JAYNES PROPERTY SKETCH PLAN

LETTER OF INTENT MEMO

MARCH 2023

## SKETCH PLAN

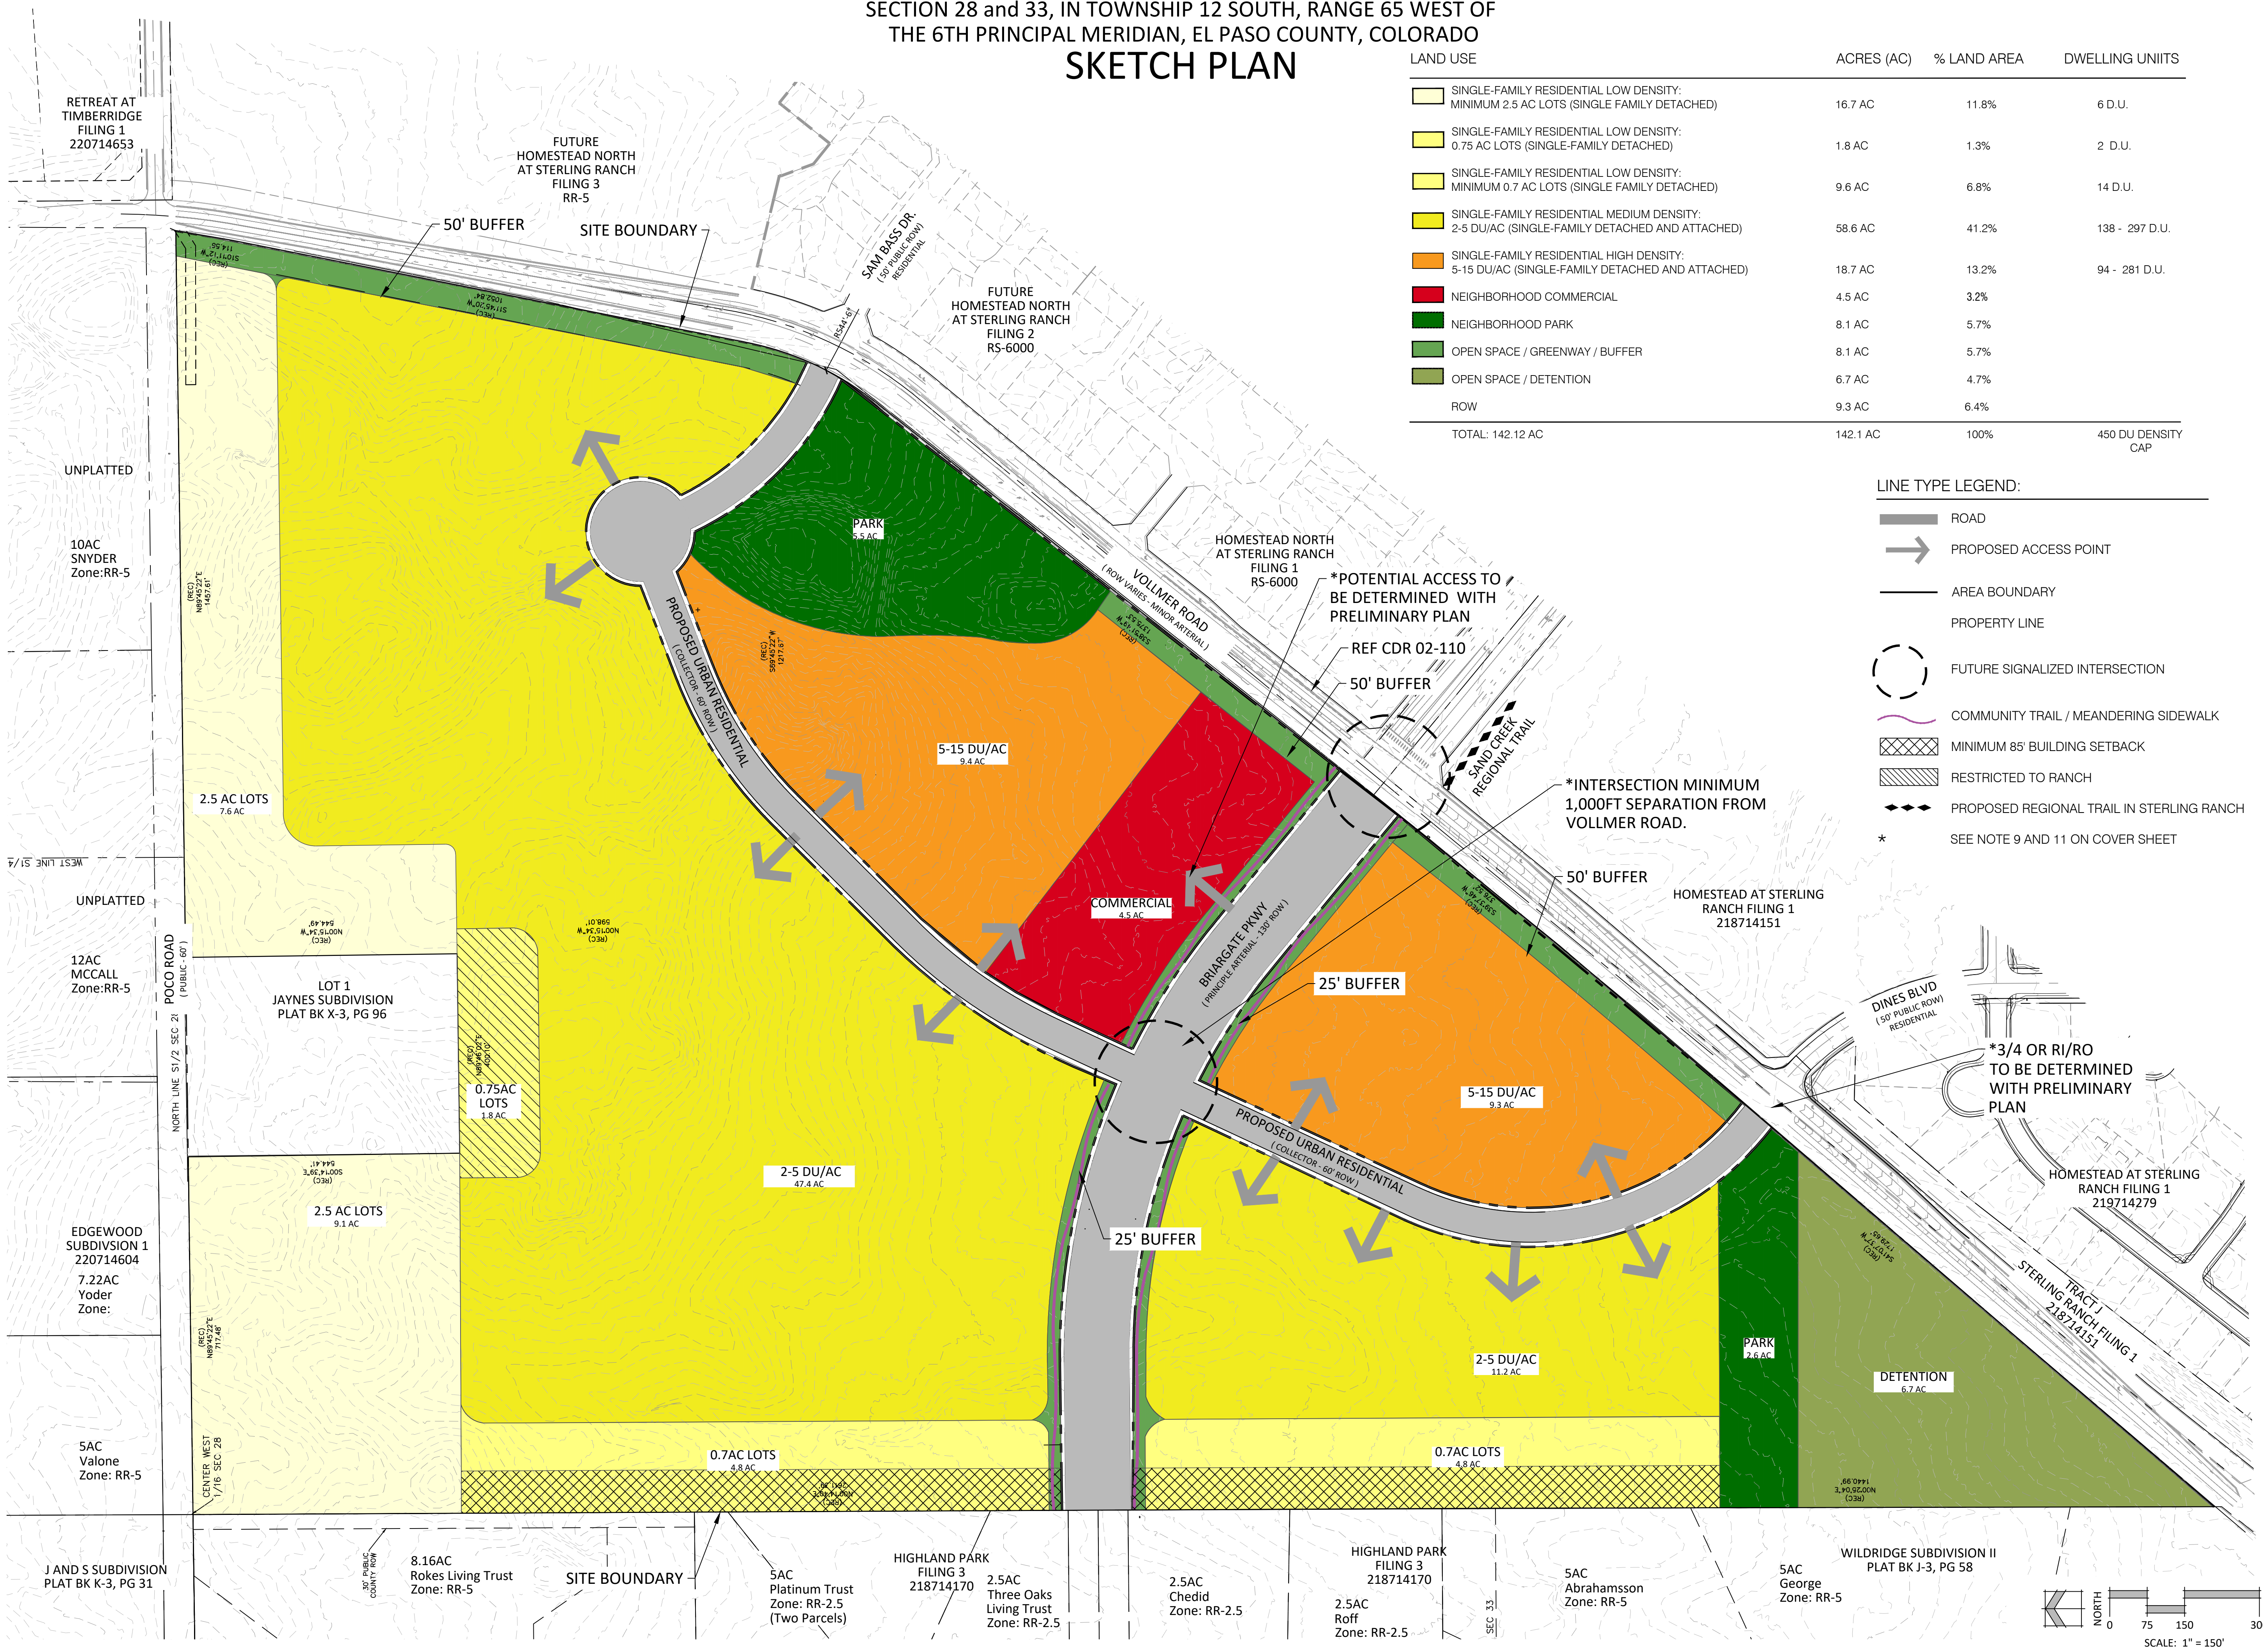
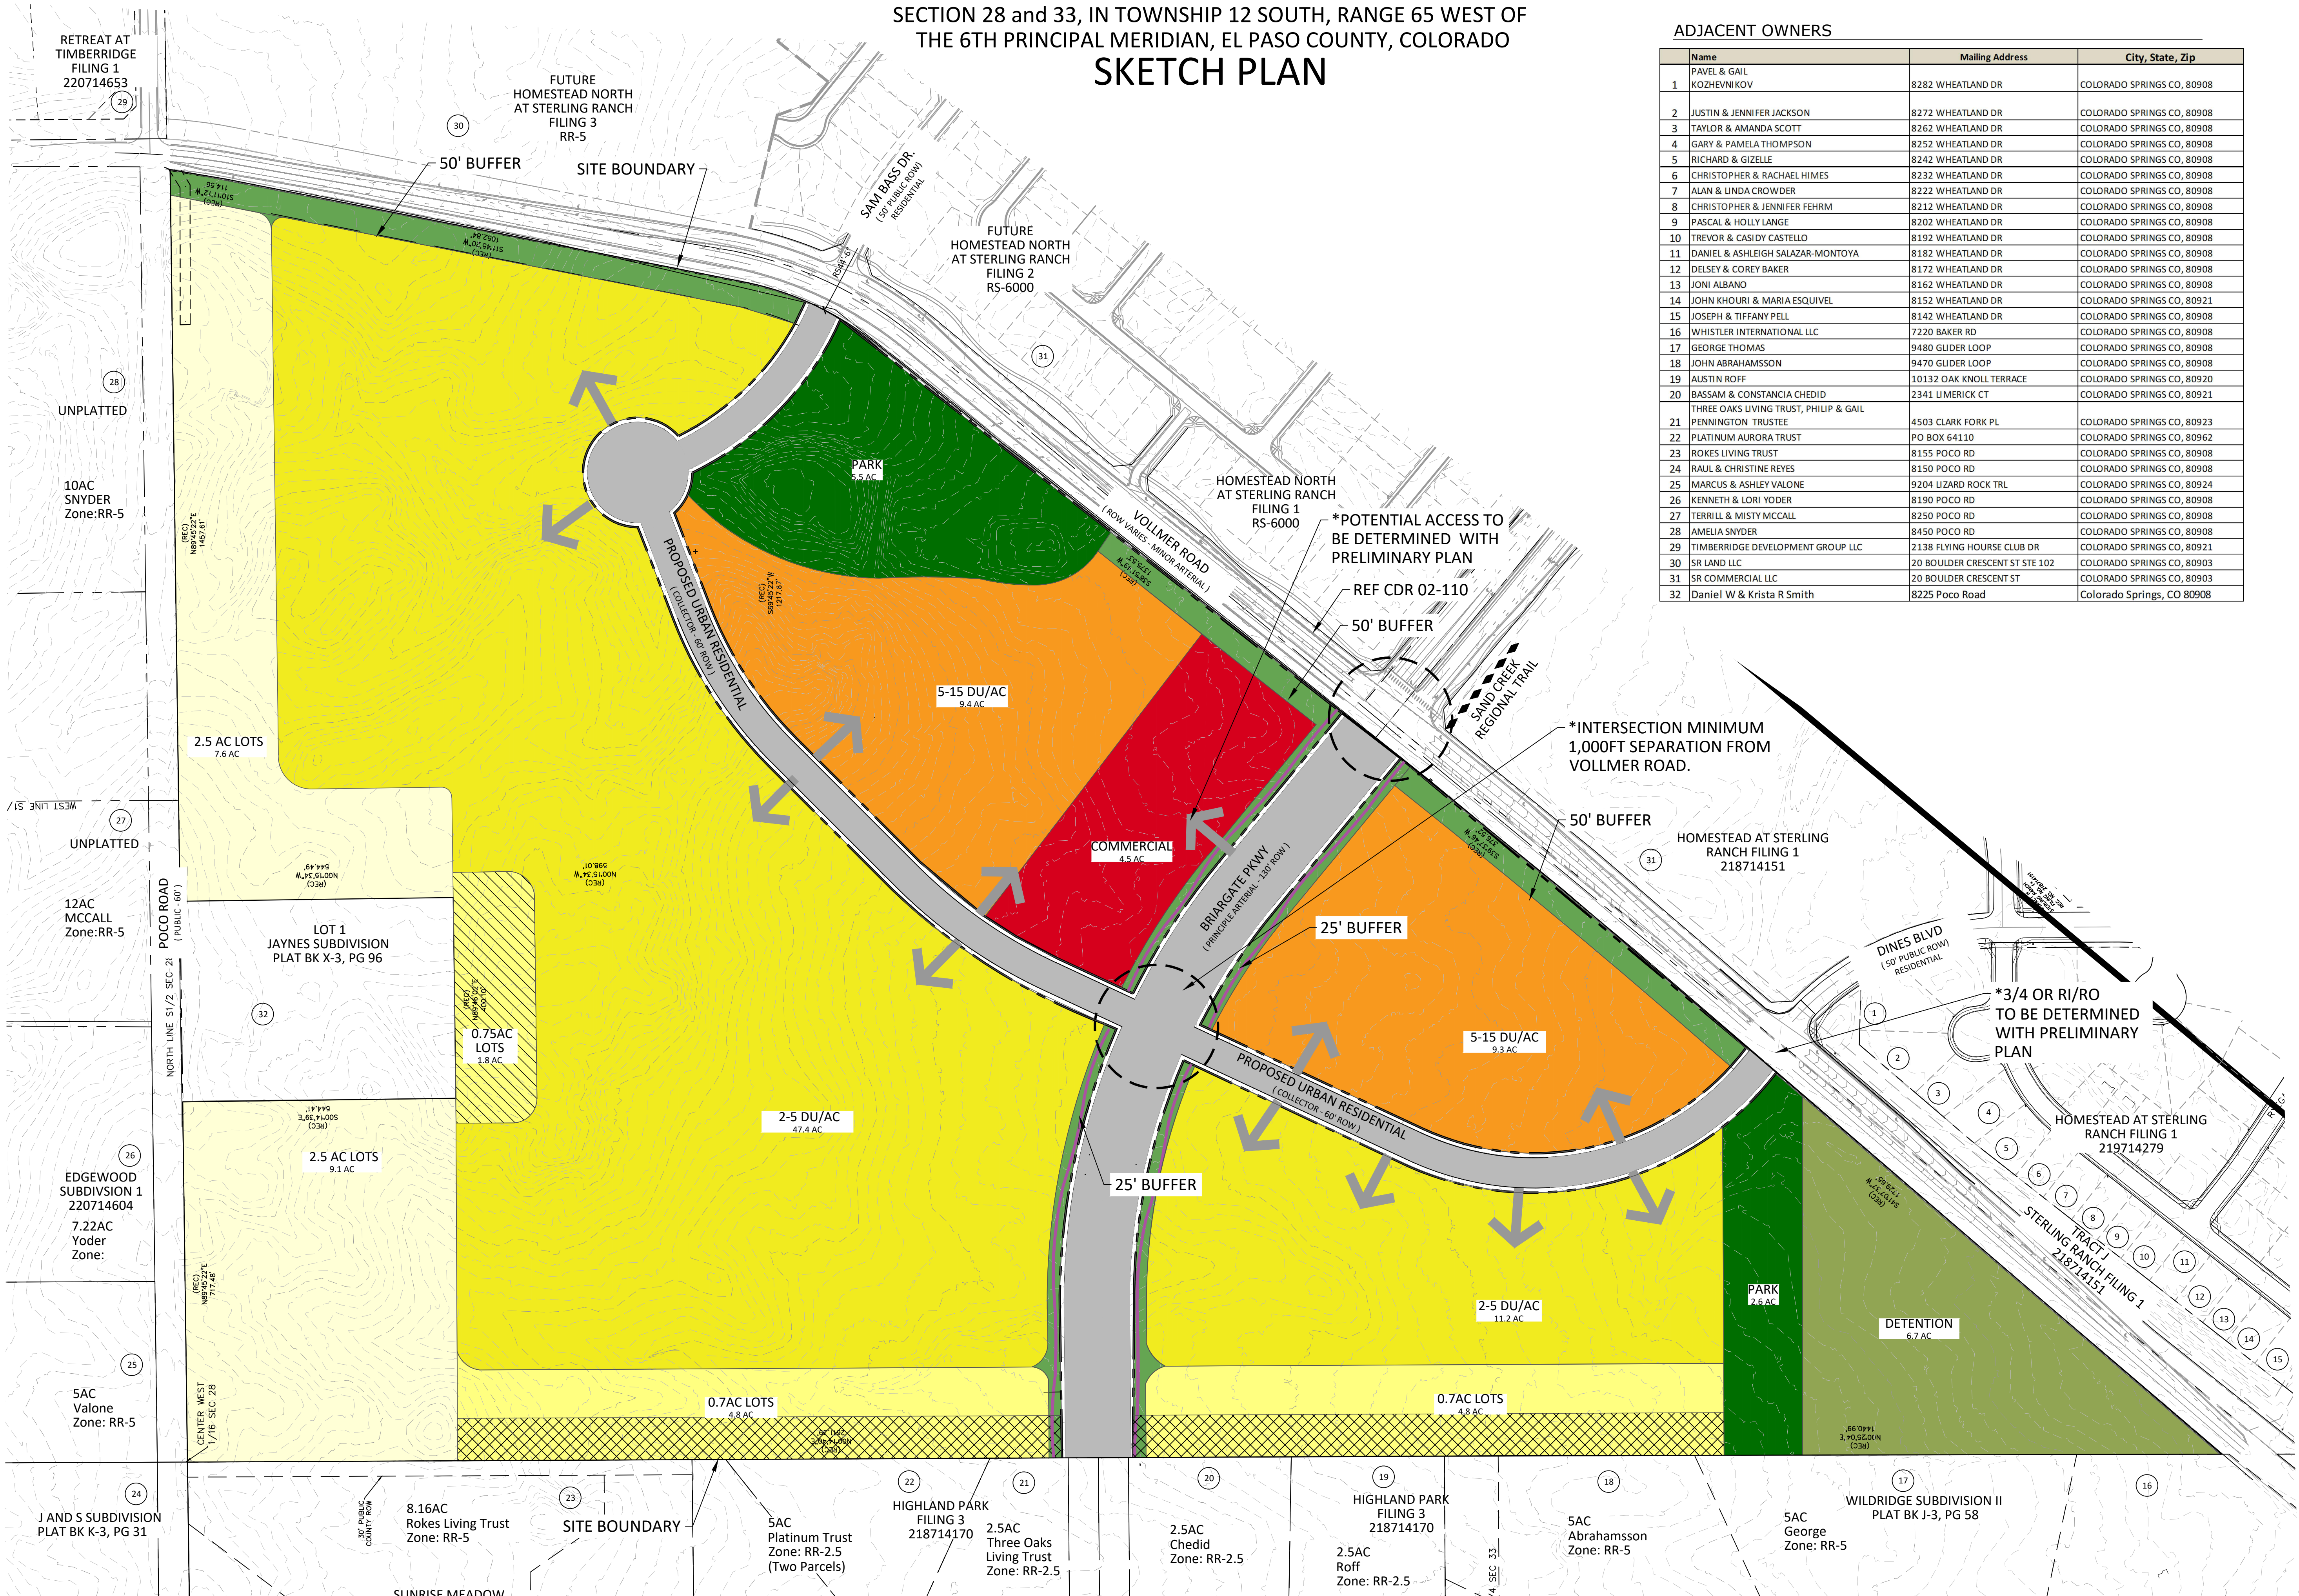
Jaynes Property Sketch Plan is amended to reflect comments received on 02/16/23 at the Planning Commission Hearing, relating to density transition from the existing rural residential lots to the north and west. Based on these comments, the following changes were made:

- Revision of 1AC lots along Poco Road to 2.5AC lots
- Removal of the 35' building setback along Poco
- Orientation of 2.5AC lots to match depth of the Smith Parcel
- Removal of the 50' buffer and 35' building setback around the Smith Lot
- Removal of the 50' buffer and trail along the west boundary
- Modification from 0.5AC lots along western boundary to 0.7AC lots with a 75' building setback by incorporating the 50' buffer into the lots.
- Increase in density interior to the site:
 - 5-12DU/AC has been changed to 5-15DU/AC
